Re: Formal objection to outline planning application 2026/60/91785/W

Site: Land adjacent to 161 Reinwood Road, Quarmby, Huddersfield

Proposal: Outline application for up to five dwellings

Dated: 20 August 2026

Development Proposals

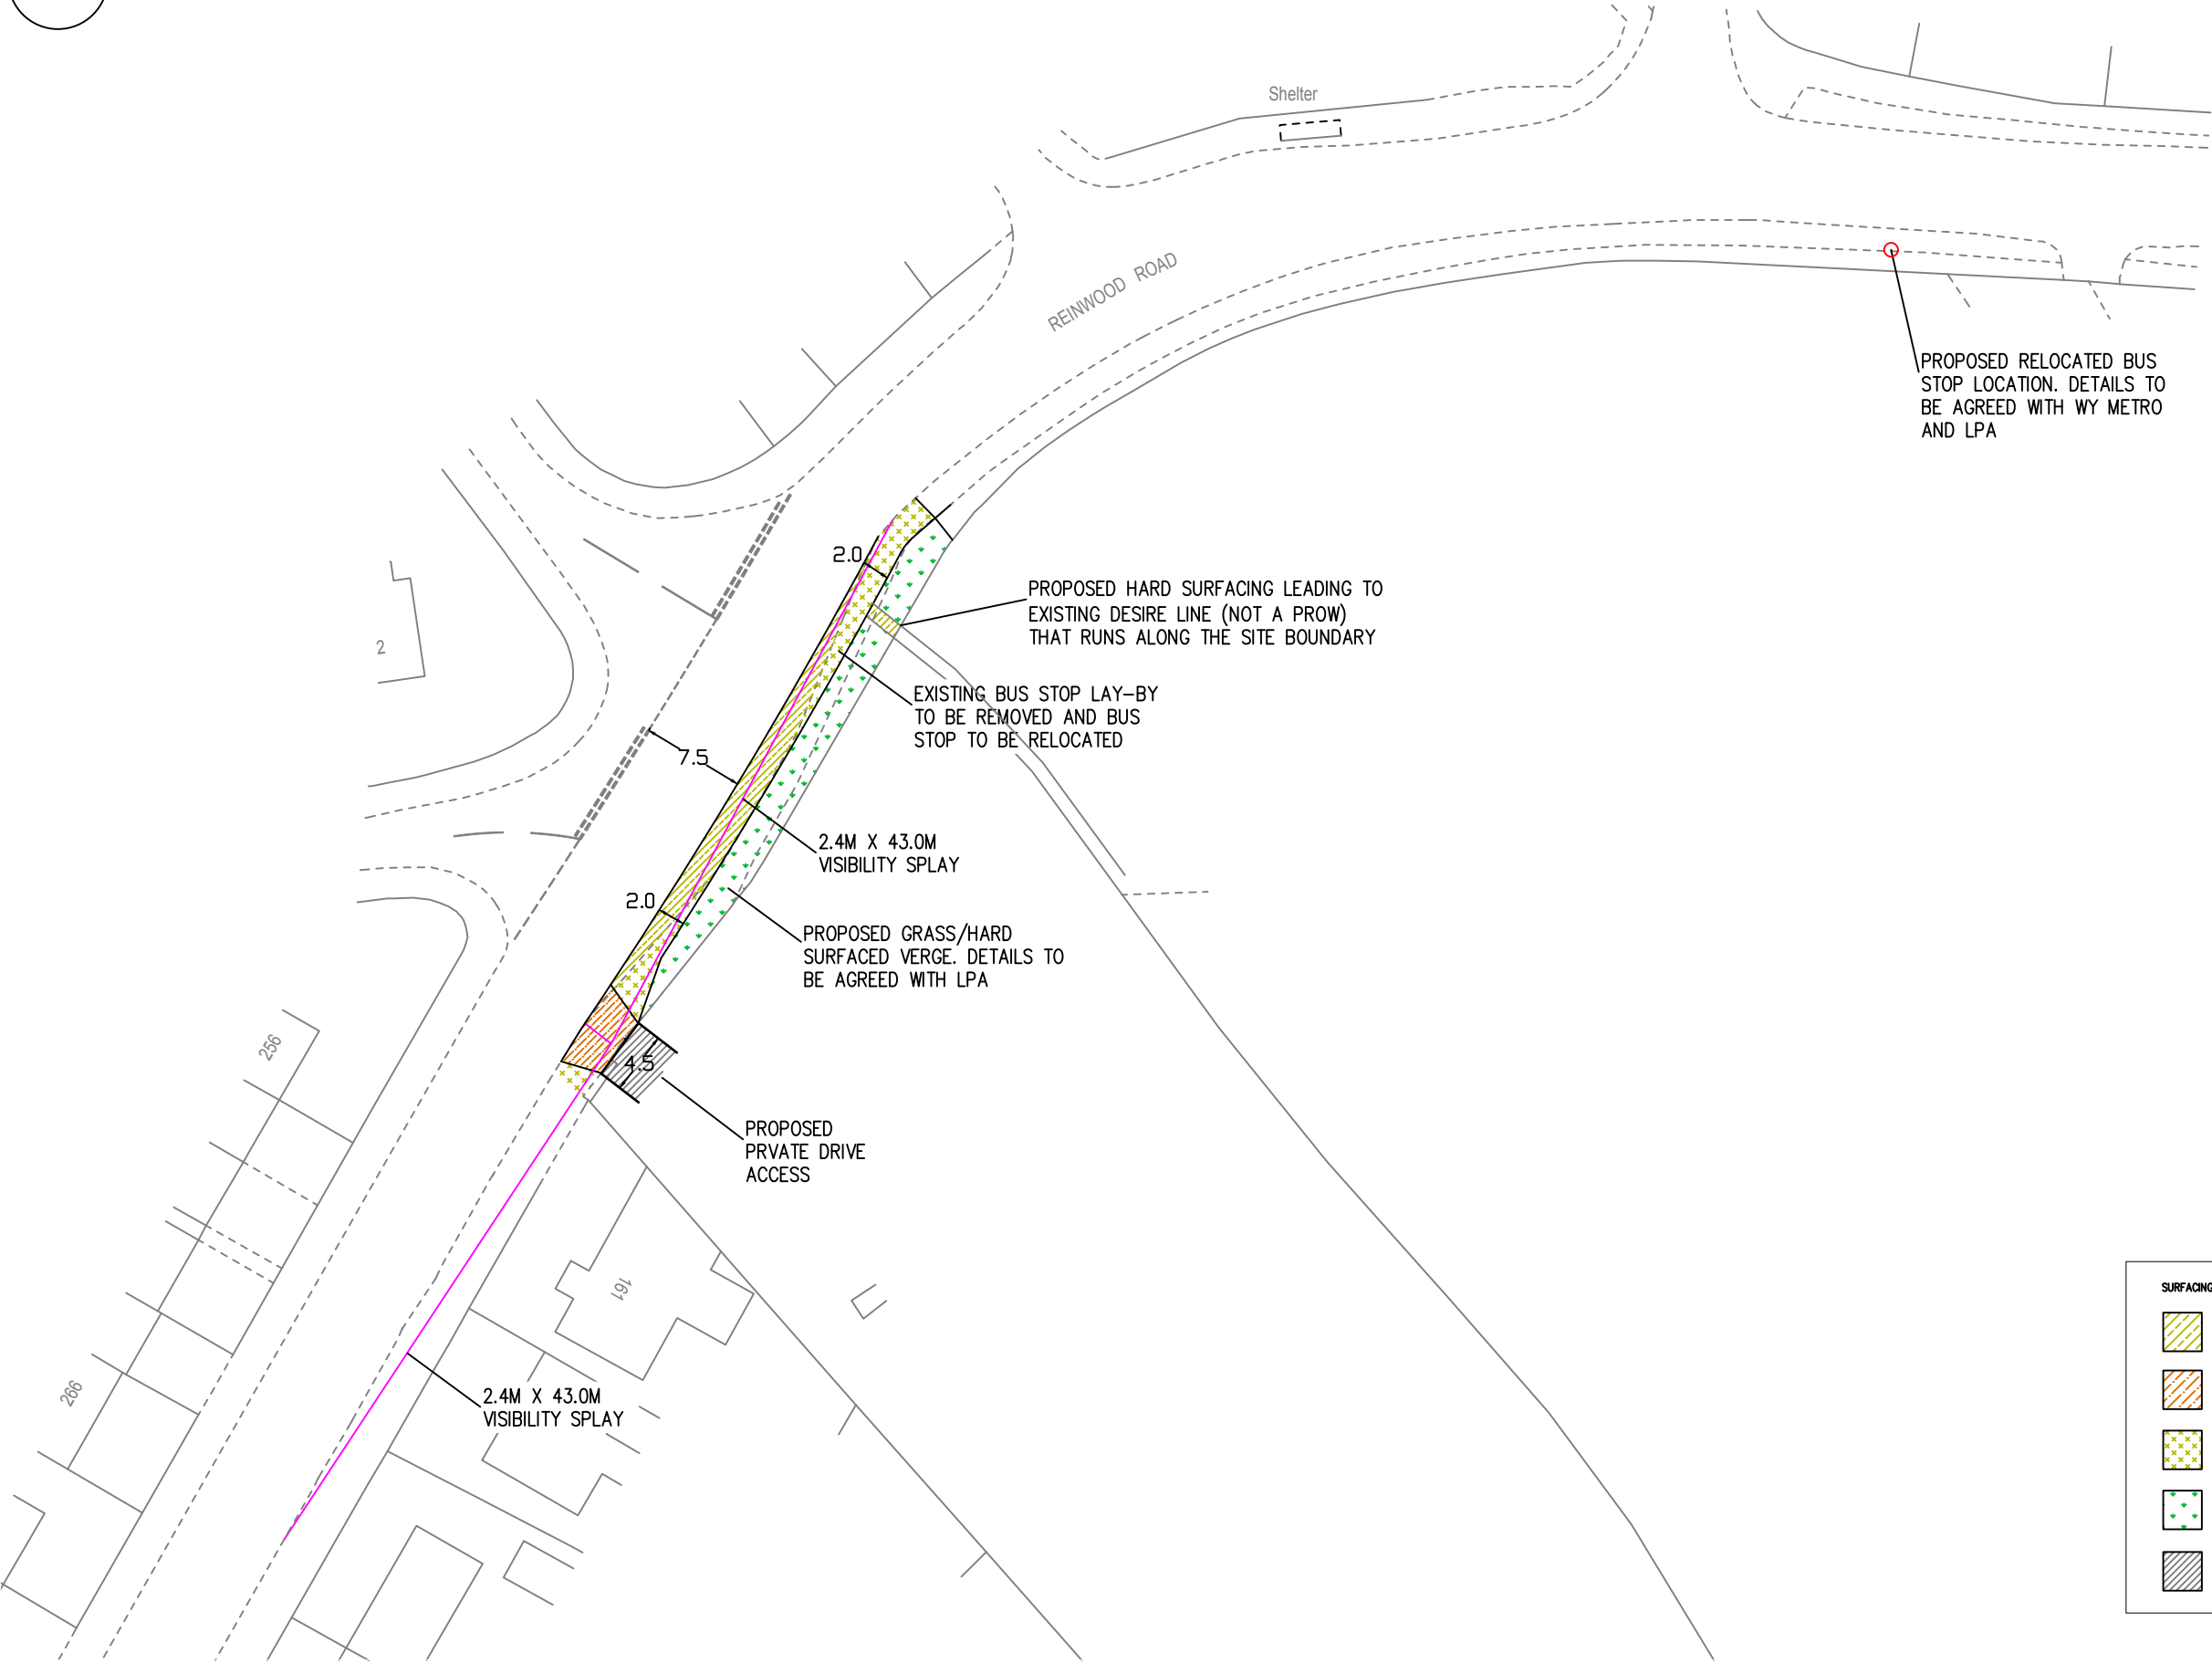
The proposed access road is a separate and serious objection. It would run directly beside the rear gardens of Nos. 21 to 27 Royd Croft. The existing relationship is between established rear gardens and undeveloped green land. The proposal would replace that with a road and associated activity.

The application does not provide enough information about road levels, boundary heights, road alignment, lighting design, vehicle direction, headlight paths, refuse arrangements or construction management. The Council should require a specific assessment of the effect on Nos. 21 to 27 Royd Croft before determining the application.

- the safety of the road junction and visibility on the bend;
- the relocation of the bus stop;
- the removal of the lay-by;
- potential conflict between vehicles, bus passengers and pedestrians;
- pedestrian movements linked to Douglas Avenue Recreation Ground and local school routes;
- the lack of dedicated internal footways and reliance on a shared-surface layout;
- vehicle tracking for refuse, emergency and delivery vehicles;
- construction traffic routing and contractor parking;
- whether peak trip assumptions are realistic for five family homes with potential multiple vehicle ownership.
